**HEYFORD PARK CAMP ROAD UPPER HEYFORD BICESTER OX25 5HD  
Application No. 18/00825/HYBRID**

**Historic England Advice**

These comments refer to the ADP document Heyford Park Proposed New Primary School Design Update revision C, dated June 2020.

1. SITE STRATEGY - ZONED PARAMETERS PLAN

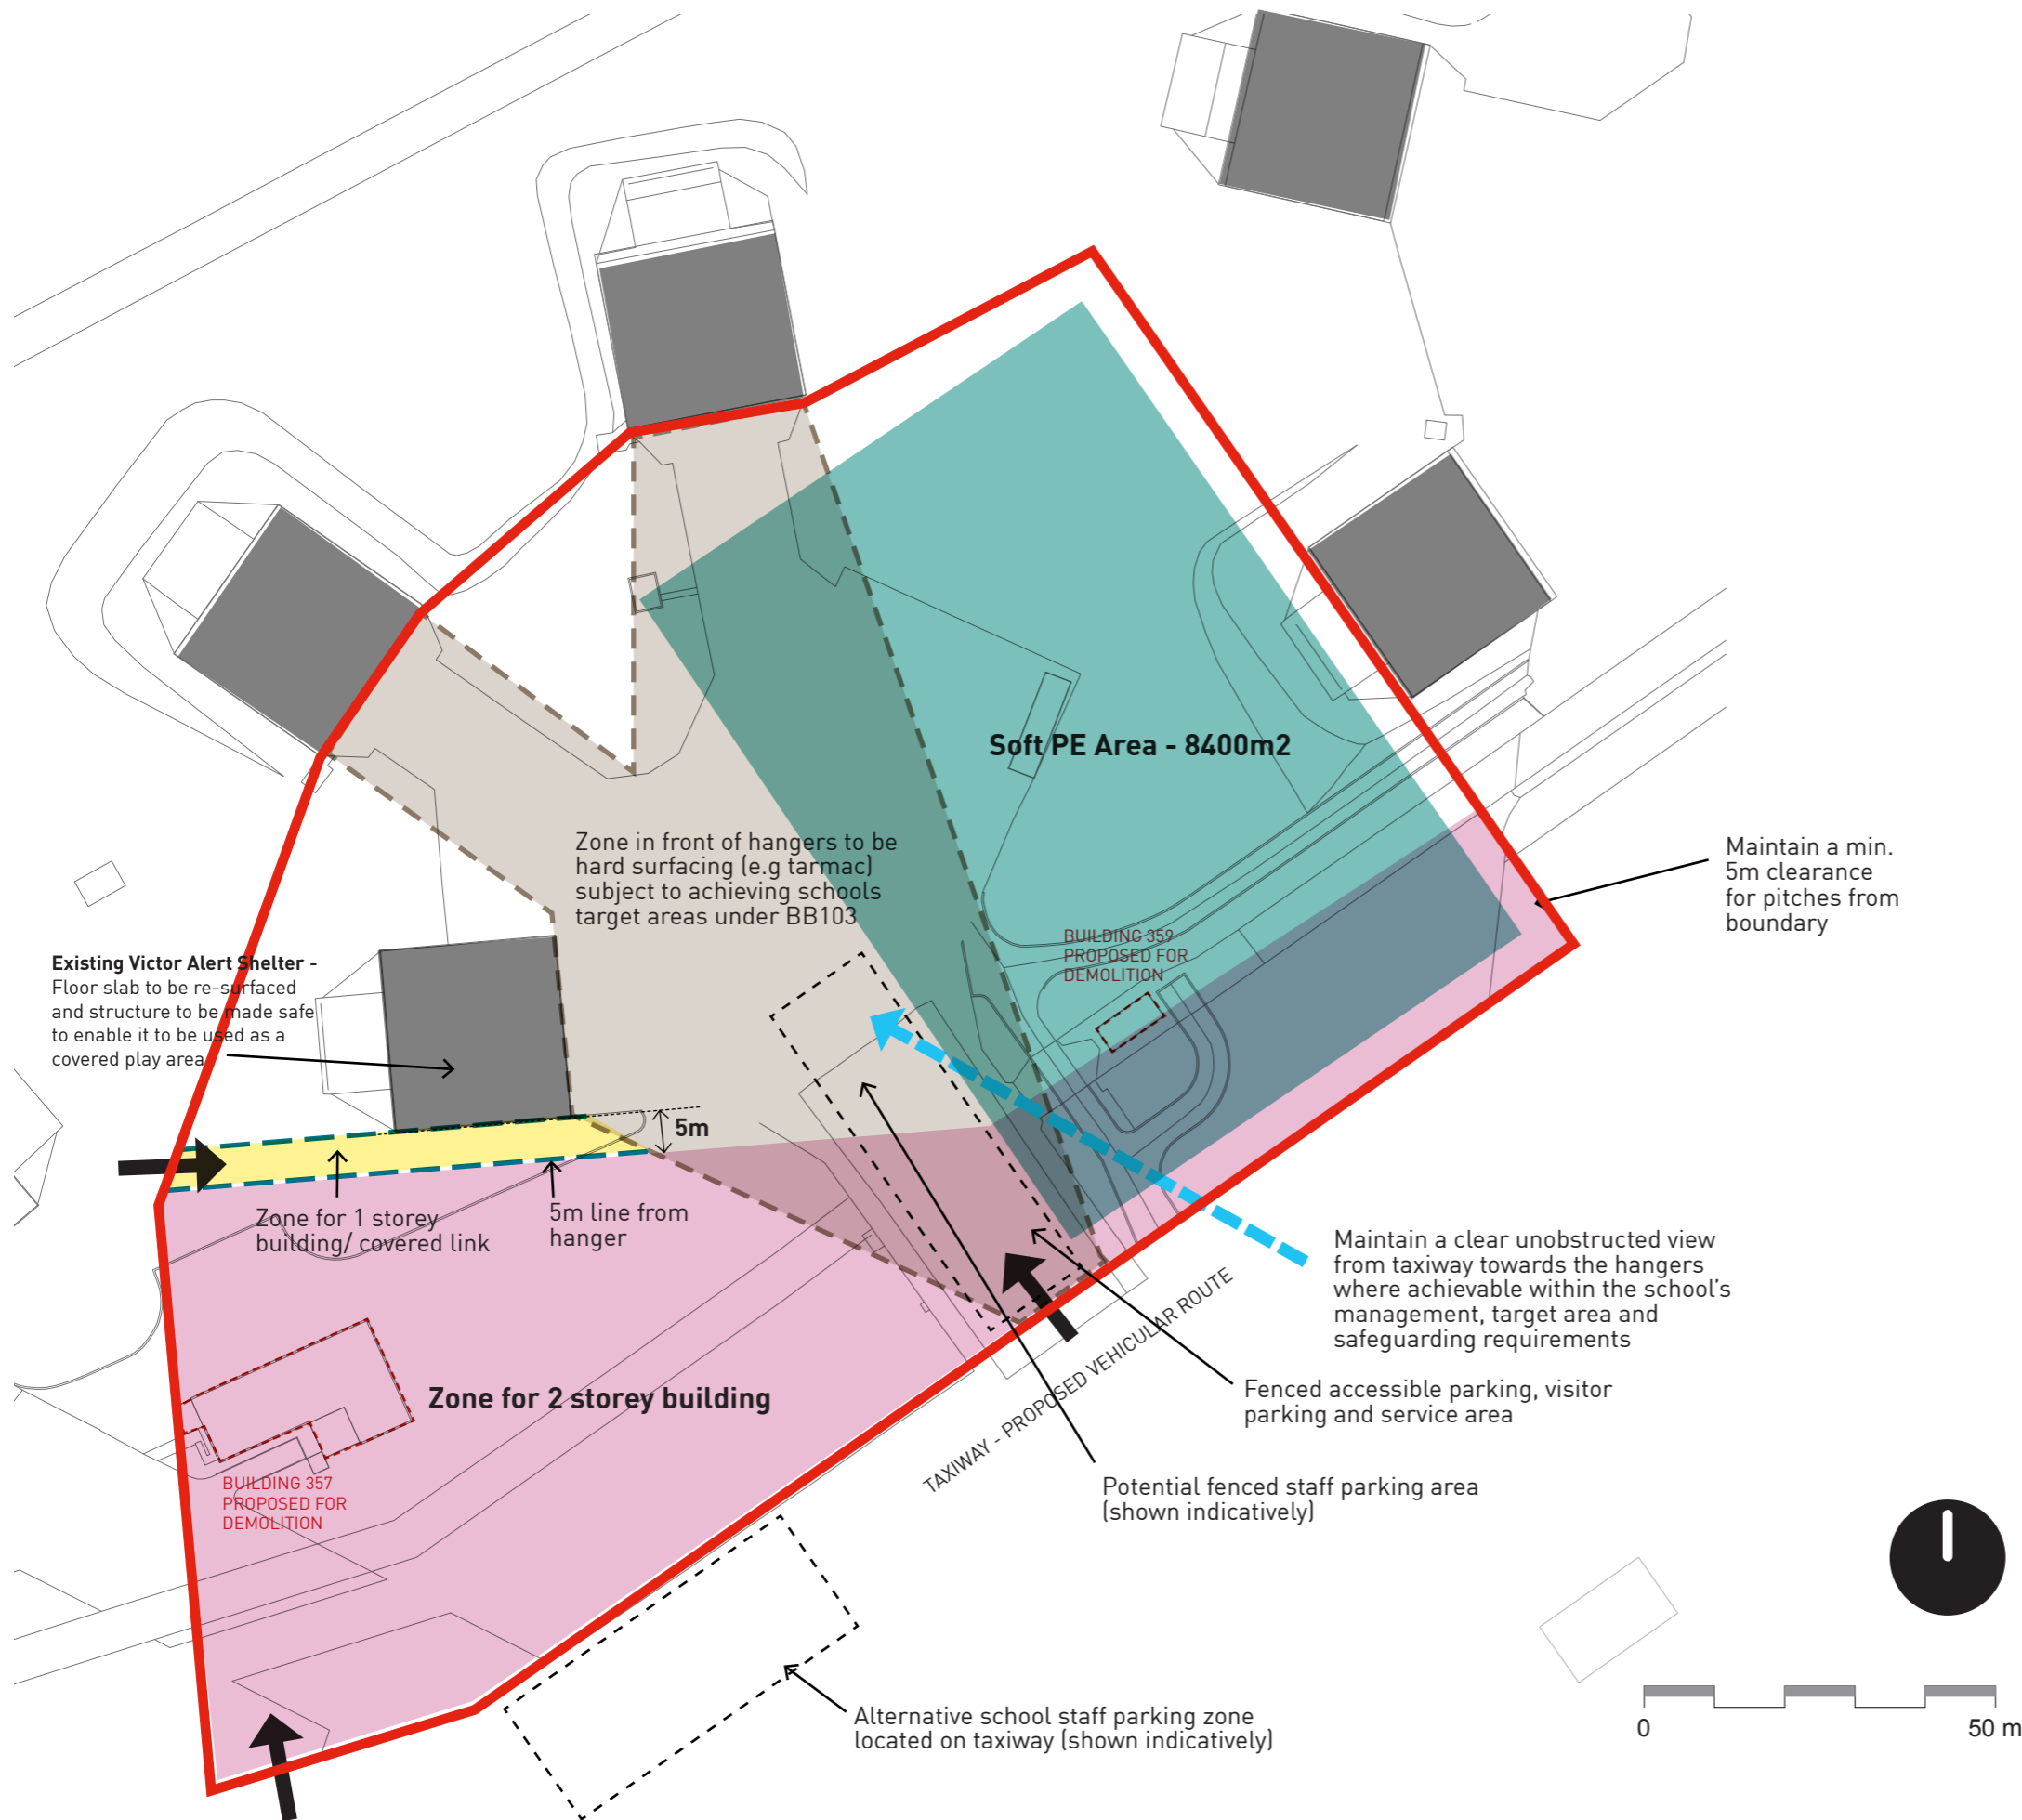
The latest revision contains a parameters plan that shows the hangars retained but still includes the large soft landscaped PE area. This would involve the loss of a sizable area of the concrete apron in front of the Victoria Alert shelters, cutting off one of the shelters from the apron entirely. The possibility of a fenced car park is also shown on the apron which would also compromise an understanding of how this part of the base worked. The loss of a large part of the apron and the creation of a fenced car park would entail a high level of harm to the significance of this part of the conservation area. We also note that there is no guarantee that the sections of apron shown as remaining on the parameter plan would be retained as this would be subject to achieving the schools target areas for soft landscaping under BB103. We understand the need to resurface the concrete with tarmac to meet the County Council's requirements and are content with this as it would still preserve the functional relationships between the hangars.

We suggest that the parameters plans are revised to ensure that the harm entailed by school use is minimised. Specifically we suggest that the fenced car park on the apron

is omitted and that the plan clearly delineates the area of apron to be retained without qualifications. Ideally this should connect all 3 aircraft shelters to the taxiway. If this is not possible the document needs to explain why the shape and location of the soft play area cannot be altered or moved (if necessary extending the fenced area) and a landscaping scheme that preserves an indication of the relationship between the apron any shelter cut off from it devised.
